Concept Approval SSD 5175 includes the following conditions relevant to the application of the Eastern Creek Business Hub Design Guidelines:

The following table considers the requirements of the Design Guidelines (DG) against the proposed Stage 1 concept and identifies:

| Eastern Creek Business Hub – Design Guidelines |

Figure 3: Indicative Landscape Master Plan (~~Urbis~~) (Group GSA)

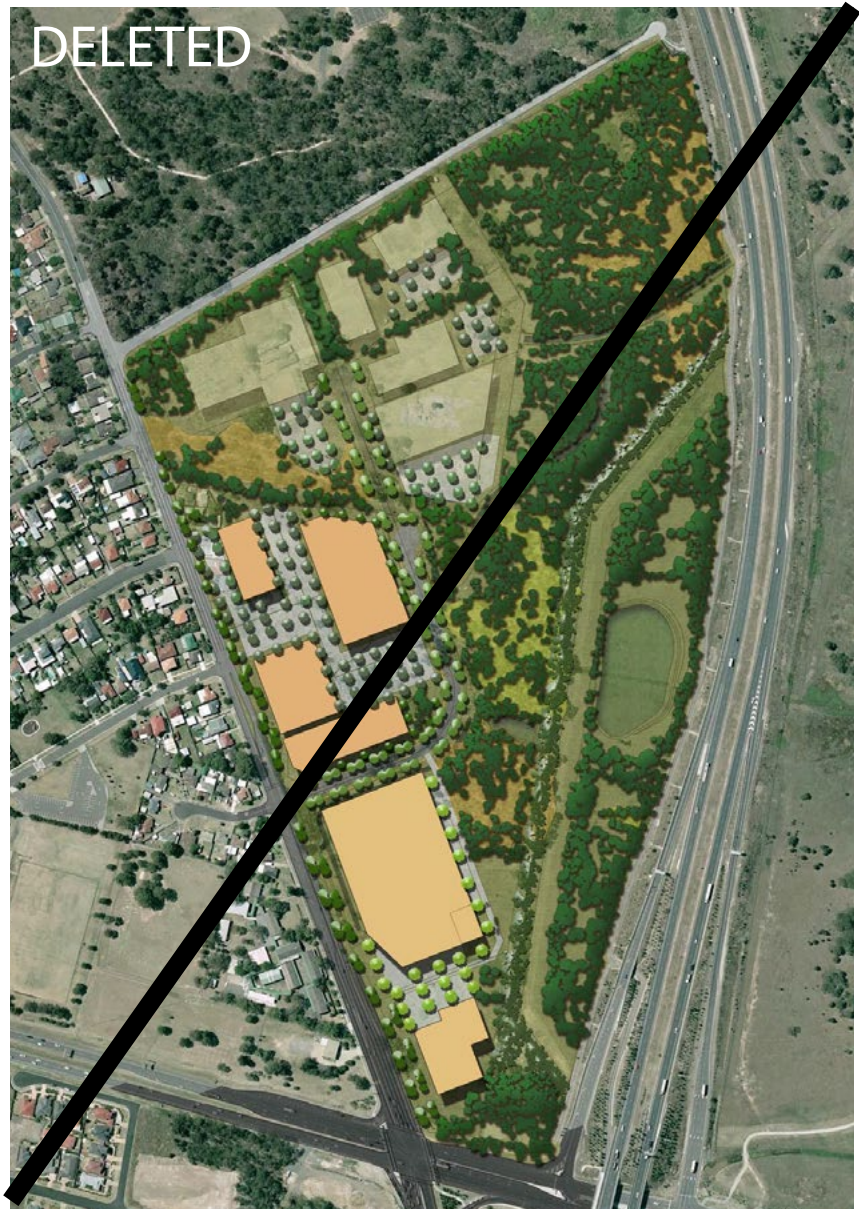
| Eastern Creek Business Hub – Design Guidelines |                                                                                                                                                                                                                                                                                                                                                                                                                                                                                                                                                                                                                                                                                                                                                                                                                                                                                                                                                                                                                                                                                                                                                                                                                                                                                                                                                                                                                                                                                                                                                                                                                                                                                                                                                                                                                  |                                                                                                                                                                                                                                                                                                                                                                                                                                                                                                                                                                                                                                                                 |                                                                                                                                                                                                                                                                                                                                                                                                                                                                                                               |
|------------------------------------------------|------------------------------------------------------------------------------------------------------------------------------------------------------------------------------------------------------------------------------------------------------------------------------------------------------------------------------------------------------------------------------------------------------------------------------------------------------------------------------------------------------------------------------------------------------------------------------------------------------------------------------------------------------------------------------------------------------------------------------------------------------------------------------------------------------------------------------------------------------------------------------------------------------------------------------------------------------------------------------------------------------------------------------------------------------------------------------------------------------------------------------------------------------------------------------------------------------------------------------------------------------------------------------------------------------------------------------------------------------------------------------------------------------------------------------------------------------------------------------------------------------------------------------------------------------------------------------------------------------------------------------------------------------------------------------------------------------------------------------------------------------------------------------------------------------------------|-----------------------------------------------------------------------------------------------------------------------------------------------------------------------------------------------------------------------------------------------------------------------------------------------------------------------------------------------------------------------------------------------------------------------------------------------------------------------------------------------------------------------------------------------------------------------------------------------------------------------------------------------------------------|---------------------------------------------------------------------------------------------------------------------------------------------------------------------------------------------------------------------------------------------------------------------------------------------------------------------------------------------------------------------------------------------------------------------------------------------------------------------------------------------------------------|
| <b>1.2 Proposal</b>                            | <p><b>The objectives of the Eastern Creek Business Hub are to:</b></p> <ul style="list-style-type: none"> <li>Utilise low value land to contribute to the long term sustainable future of the Western Sydney Parklands and generate jobs for western Sydney.</li> <li>Provide for the conservation and rehabilitation of significant landscape elements, including remnant vegetation and threatened species.</li> <li>Establish an environmentally and commercially viable framework for the Business Hub.</li> </ul>                                                                                                                                                                                                                                                                                                                                                                                                                                                                                                                                                                                                                                                                                                                                                                                                                                                                                                                                                                                                                                                                                                                                                                                                                                                                                           | <p><b>Images:</b></p> <ul style="list-style-type: none"> <li>Figure 3: Indicative Landscape Plan, amended as per revised concept plan</li> </ul>                                                                                                                                                                                                                                                                                                                                                                                                                                                                                                                |                                                                                                                                                                                                                                                                                                                                                                                                                                                                                                               |

Figure 31: Large Lot Subdivision Figure 30: Indicative Lot Subdivision Option 1

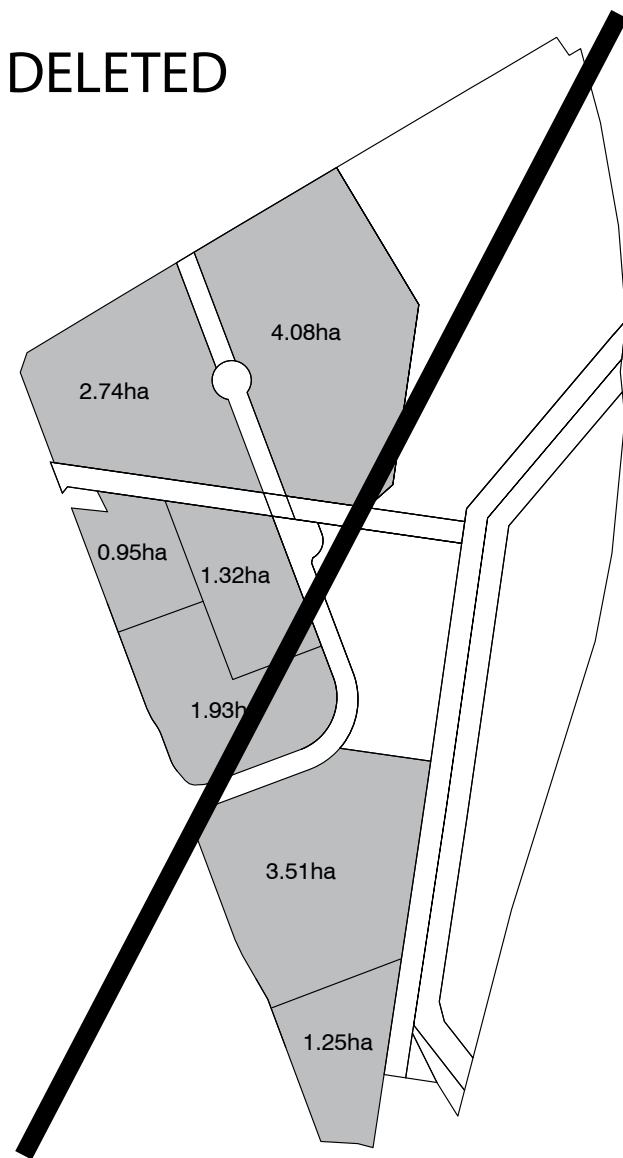
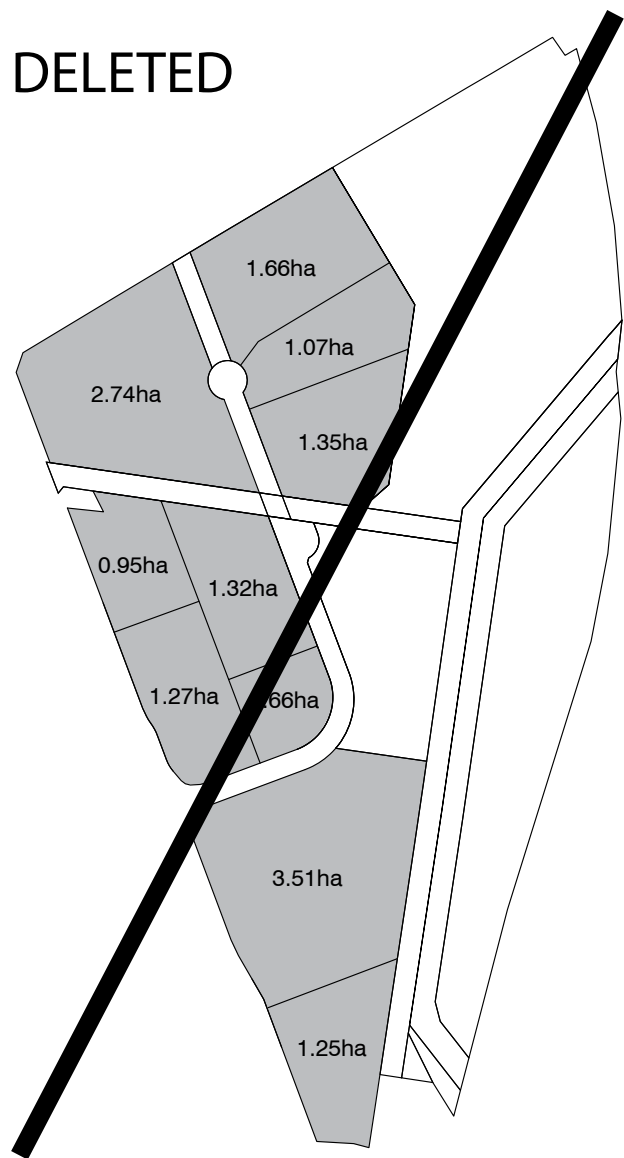
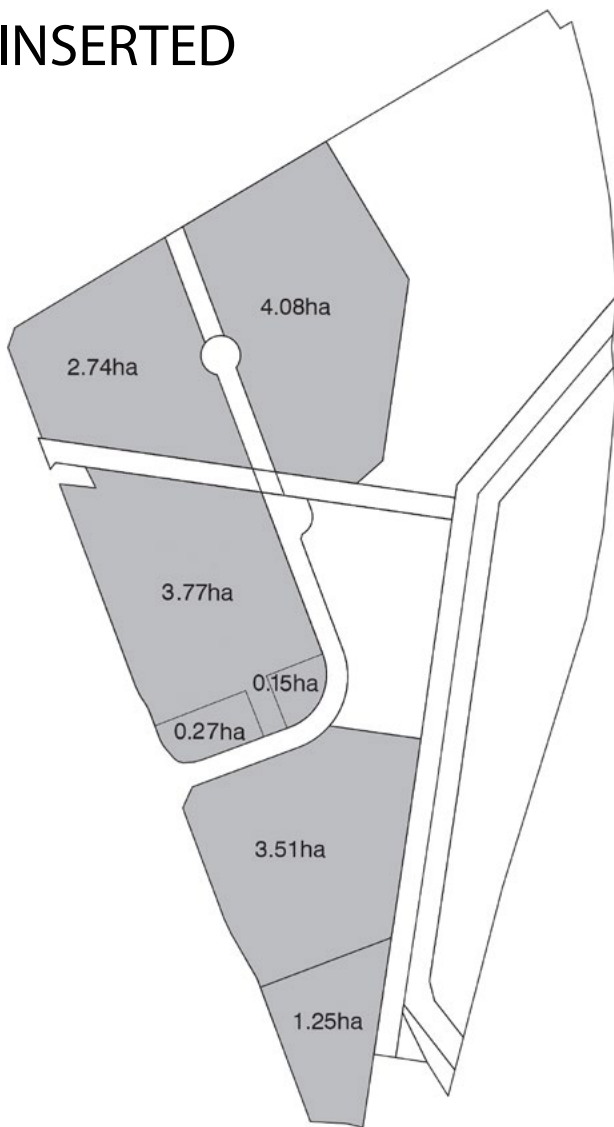
| Eastern Creek Business Hub – Design Guidelines |                                                                                                                                                                                                                                                                                                                                                                                                                                                                                                                                                                                                                                                                                                                                                                                                                                                                                                                                                                                                                                                                                                                                                                                                                                                                                                                                                                                                                                                                                  |                                                                                                                                                                                                                                                                                                                                                                                                                                                                                                                                                                                                                                                                                                                                                                                                                                                                                                                                                                                                                                                                                                                                                                                                                                                  |          |
|------------------------------------------------|----------------------------------------------------------------------------------------------------------------------------------------------------------------------------------------------------------------------------------------------------------------------------------------------------------------------------------------------------------------------------------------------------------------------------------------------------------------------------------------------------------------------------------------------------------------------------------------------------------------------------------------------------------------------------------------------------------------------------------------------------------------------------------------------------------------------------------------------------------------------------------------------------------------------------------------------------------------------------------------------------------------------------------------------------------------------------------------------------------------------------------------------------------------------------------------------------------------------------------------------------------------------------------------------------------------------------------------------------------------------------------------------------------------------------------------------------------------------------------|--------------------------------------------------------------------------------------------------------------------------------------------------------------------------------------------------------------------------------------------------------------------------------------------------------------------------------------------------------------------------------------------------------------------------------------------------------------------------------------------------------------------------------------------------------------------------------------------------------------------------------------------------------------------------------------------------------------------------------------------------------------------------------------------------------------------------------------------------------------------------------------------------------------------------------------------------------------------------------------------------------------------------------------------------------------------------------------------------------------------------------------------------------------------------------------------------------------------------------------------------|----------|
|                                                |                                                                                                                                                                                                                                                                                                                                                                                                                                                                                                                                                                                                                                                                                                                                                                                                                                                                                                                                                                                                                                                                                                                                                                                                                                                                                                                                                                                                                                                                                  | <ul style="list-style-type: none"> <li>Figure 31: Large Lot Subdivision and Figure 32: Medium Lot Subdivision amended as per revised concept plan, now captioned “Figure 30: Indicative Lot Subdivision Option 1” and “Figure 31: Indicative Lot Subdivision Option 2”.</li> </ul>                                                                                                                                                                                                                                                                                                                                                                                                                                                                                                                                                                                                                                                                                                                                                                                                                                                                                                                                                               |          |

| Eastern Creek Business Hub – Design Guidelines |                                                                                                                                                                                                                                                                                                                                                                                                                                                                                                                                                                                                                                                                                                                                                                                                                                       |                                                                                                                                                                                                                                                                                                                                                                                                                                                                                                                                                                                                                                                                                                                                                                                                                                                                    |                                                                                   |
|------------------------------------------------|---------------------------------------------------------------------------------------------------------------------------------------------------------------------------------------------------------------------------------------------------------------------------------------------------------------------------------------------------------------------------------------------------------------------------------------------------------------------------------------------------------------------------------------------------------------------------------------------------------------------------------------------------------------------------------------------------------------------------------------------------------------------------------------------------------------------------------------|--------------------------------------------------------------------------------------------------------------------------------------------------------------------------------------------------------------------------------------------------------------------------------------------------------------------------------------------------------------------------------------------------------------------------------------------------------------------------------------------------------------------------------------------------------------------------------------------------------------------------------------------------------------------------------------------------------------------------------------------------------------------------------------------------------------------------------------------------------------------|-----------------------------------------------------------------------------------|
| <b>3.1.1 Subdivision layout</b>                | <p><b>Objectives</b></p> <p>O1. Ensure flexibility for lot layouts to allow for various employment uses to accommodate large format retailers, destination bulky goods, bulky goods and convenience retail.</p> <p>O2. Provide deep allotments that reflect the needs of employment development.</p> <p>O3. Ensure efficient utilisation of the development area.</p> <p><b>Controls</b></p> <p>C1. Subdivision is to be undertaken generally in accordance with the proposed subdivision plan.</p> <p>C2. Subdivision of super lots to enable flexibility for future lot subdivision in response to market demands. An example of future lot subdivision for large and medium lots is illustrated in Figure 31 and 32.</p> <p>C3. Maintain reserve for Phase 2 Access Road extension and pedestrian connection to Church Street.</p> | <p><b>Deleted:</b></p> <p>O1. Ensure flexibility for lot layouts to allow for various employment uses to accommodate large format retailers, destination bulky goods, bulky goods and convenience retail.</p> <p>C2. Subdivision of super lots to enable flexibility for future lot subdivision in response to market demands. An example of future lot subdivision for large and medium lots is illustrated in Figure 31 and 32.</p> <p><b>Inserted:</b></p> <p>O1. Ensure flexibility for lot layouts to allow for various employment uses to accommodate large format retailers, destination bulky goods, bulky goods, convenience retail and childcare.</p> <p>C2. Subdivision of super lots to enable flexibility for future lot subdivision in response to market demands. Examples of future lot subdivision is illustrated in Figure 30 and Figure 31.</p> | Subdivision plans were amended to be consistent with the revised concept plan.    |
